F PLANNING REPORT

Belvor Close, Spalding, Lincolnshire. PE11 3FZ

Planning Reference H14-0391-21

Erection of chill store, collation, loading dock together with offices, self store containers and car parking.

Drawing Title	PROPOSED PLANS GROUND FLOOR			Drawing number	dC/587F/03		
Scale	1 : 200	Drawn	DB	Revision	A		
Date	FEB 21	Checked

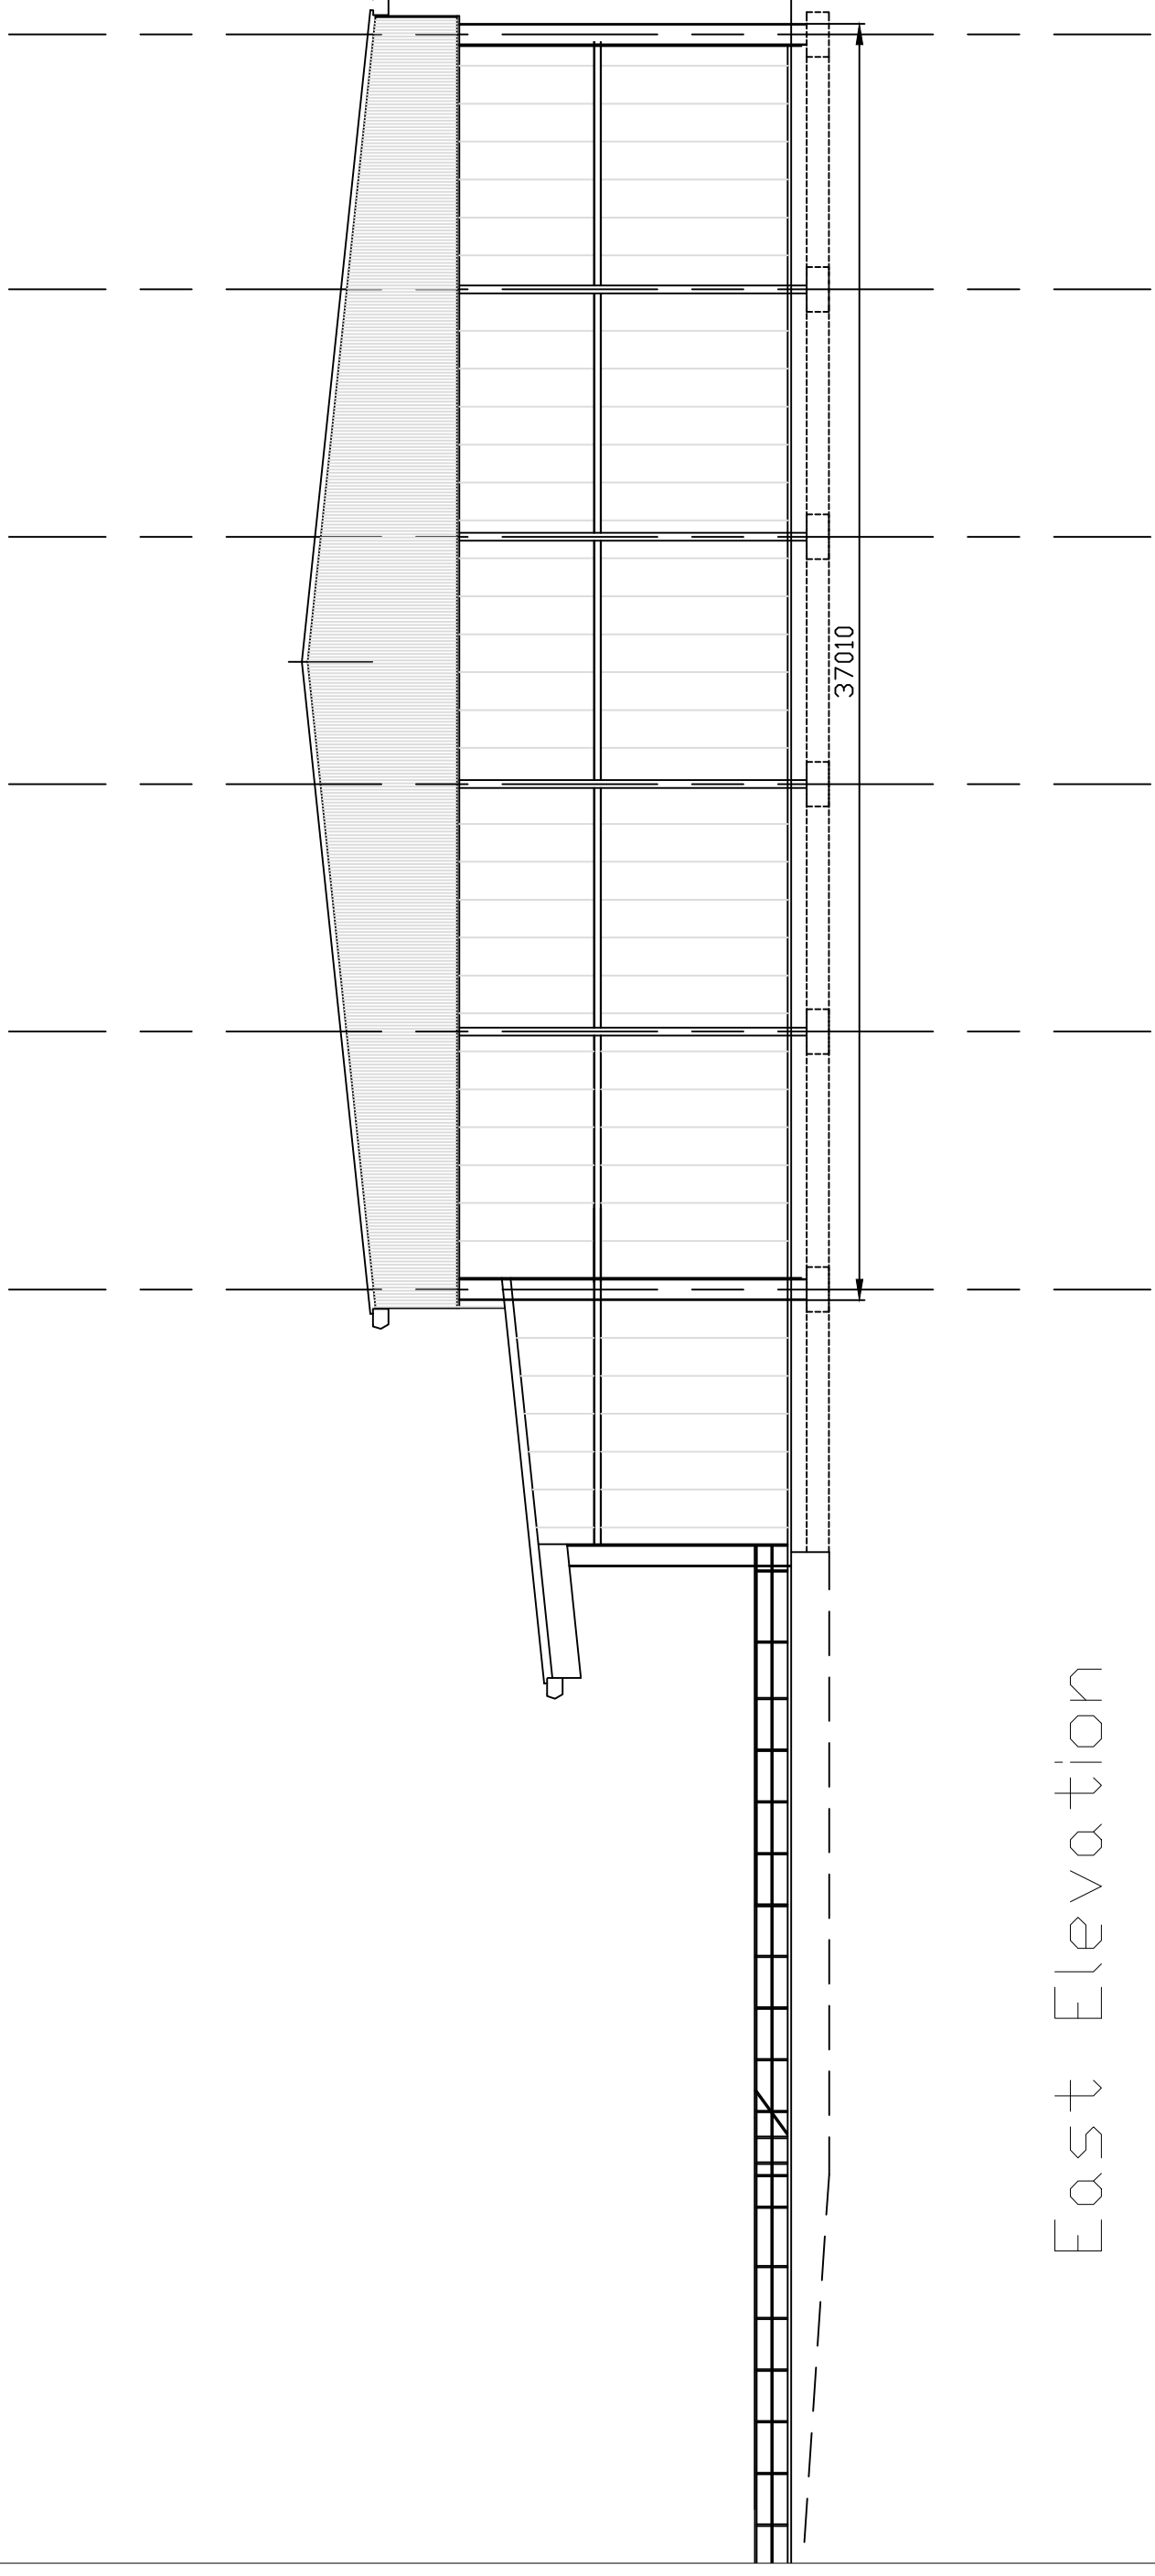
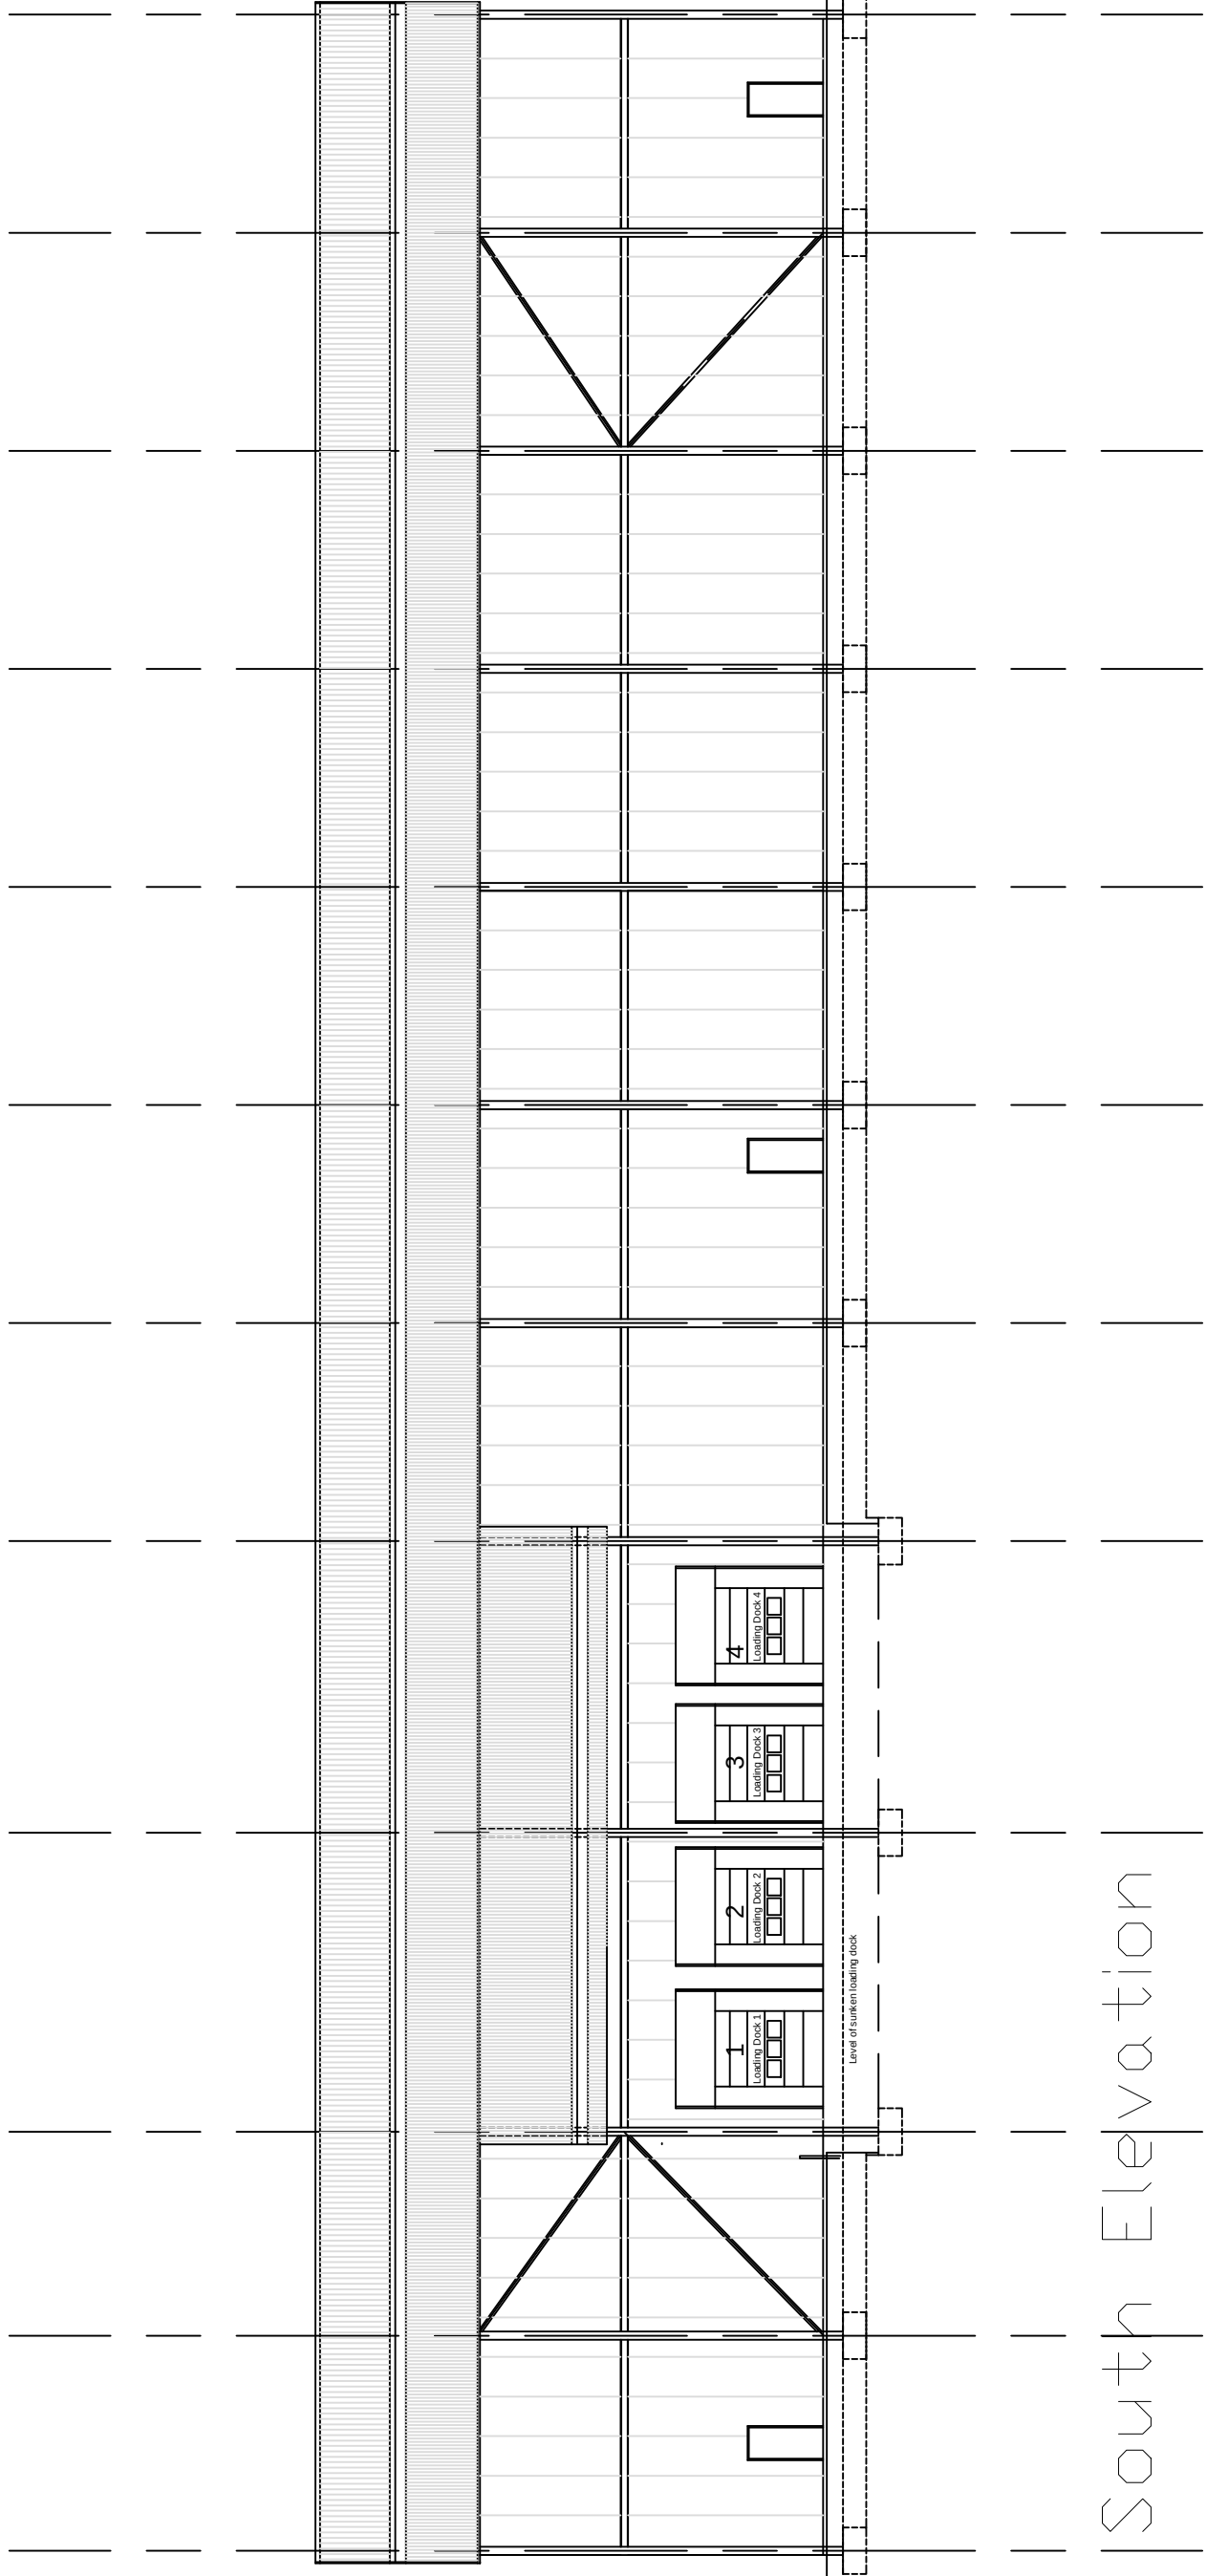
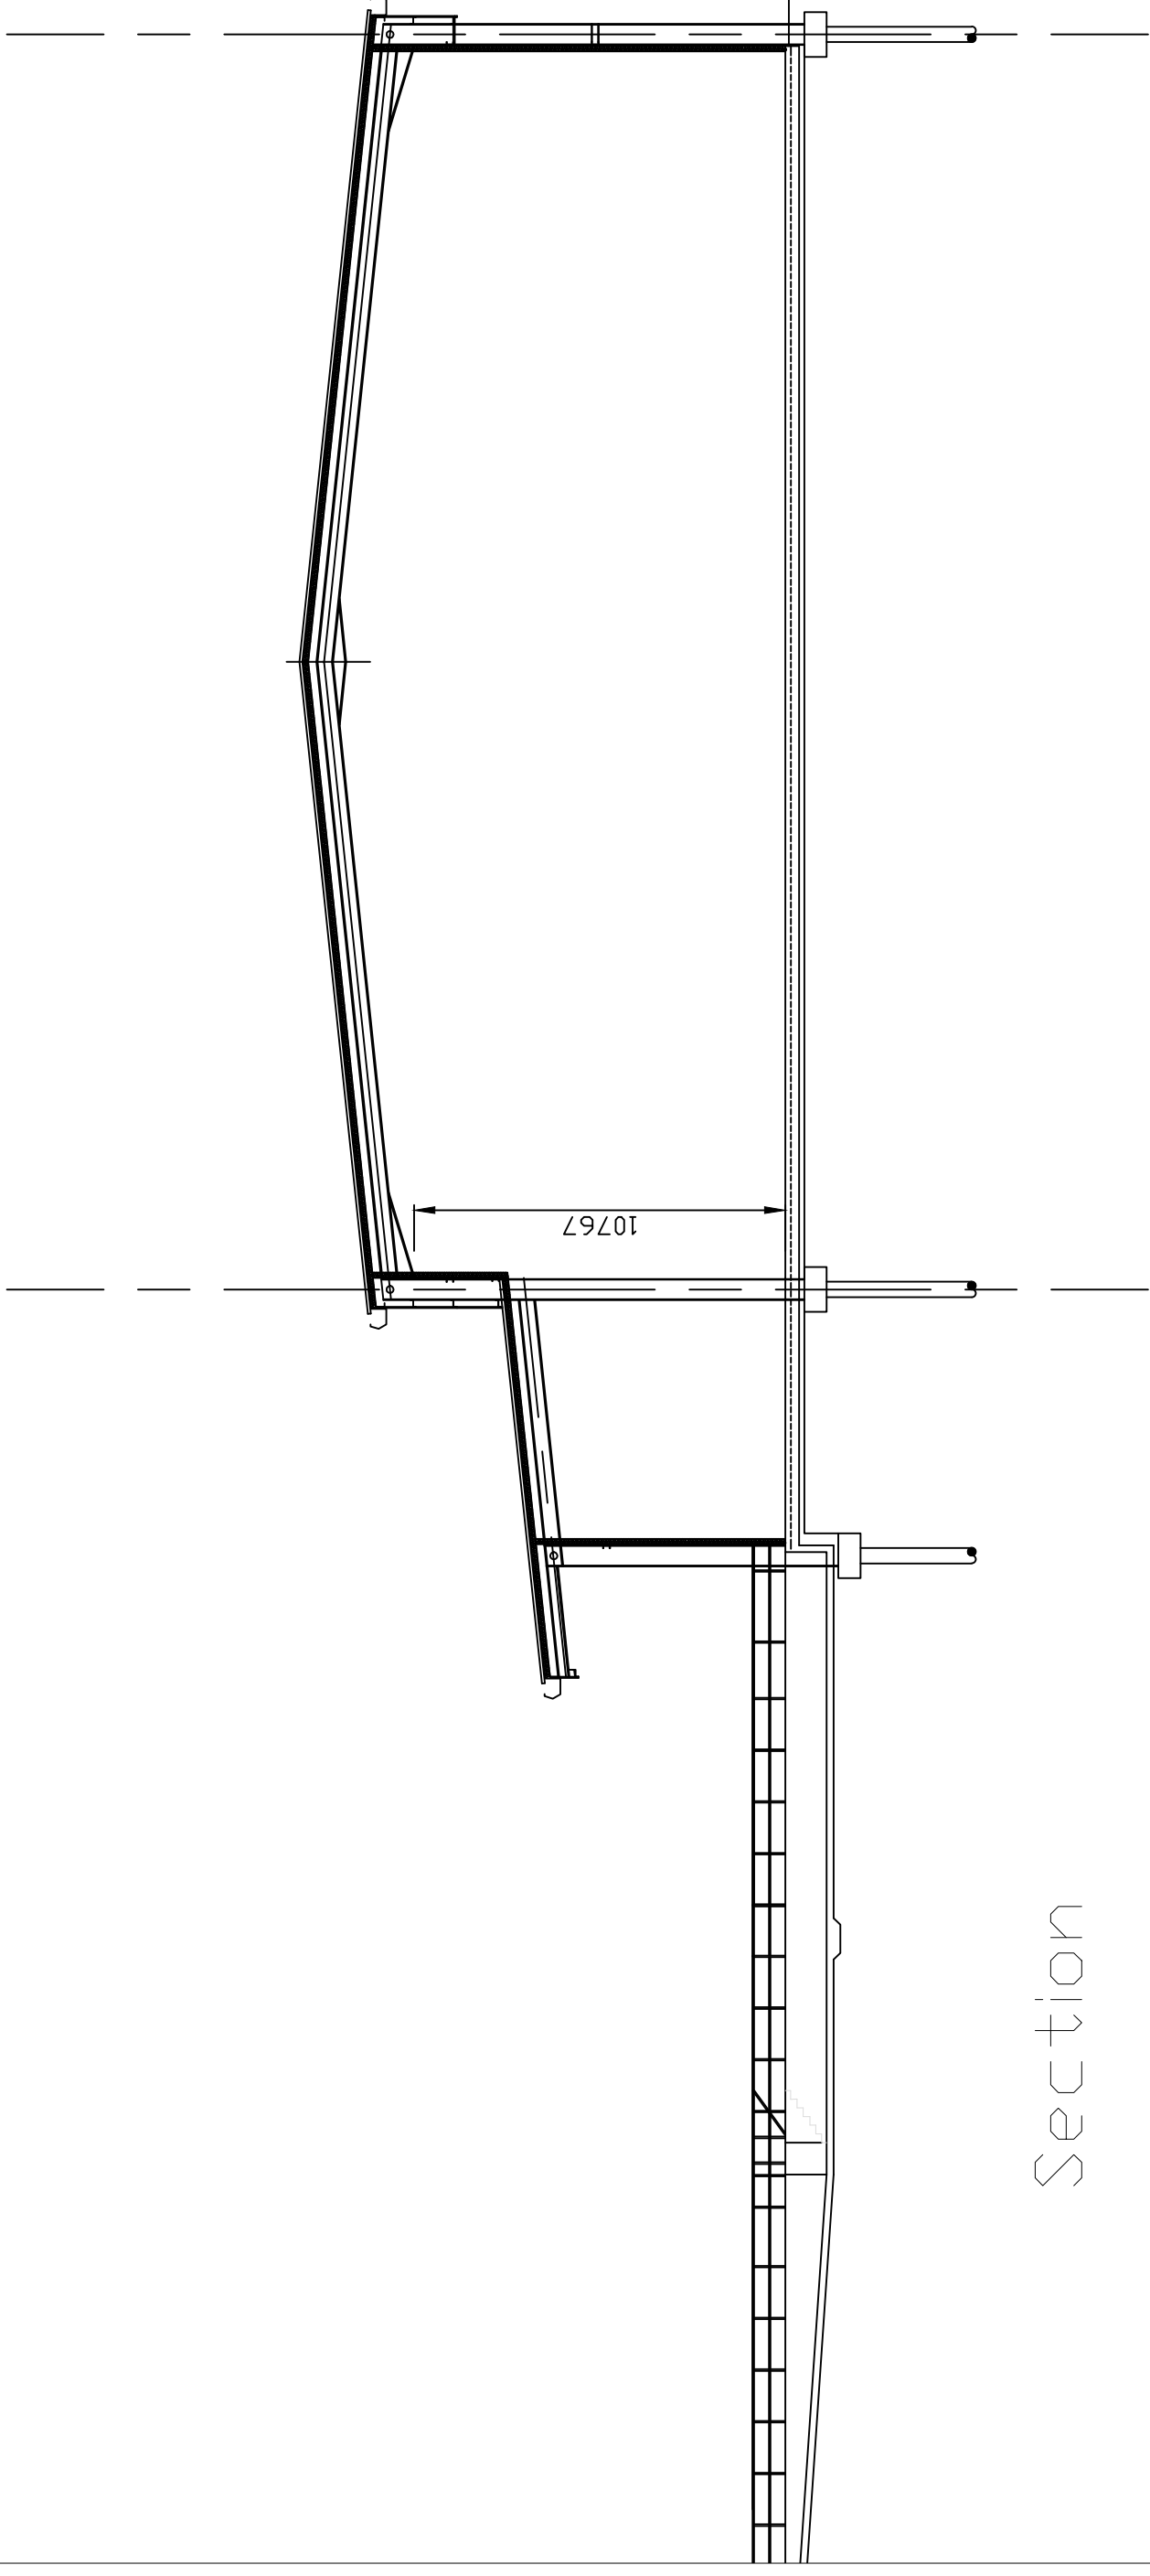
We are aware of local flood risk and standing advise in relation to floor levels however floor levels need to be practical and we have adopted our approach on this basis the proposal of 3.150m ODN floor level is actually 250mm higher that the existing buildings on freshlinc site which is 2.900m ODN. This is as high as we believe is practicable given the interaction of site operations. Raising the floor levels further is not an available option. Consideration given to preventing flood water entering the building is also not practical as the projected depths of 0.5 to 1.0 m would cause structural damage to walls and loading docks are impossible to water seal.
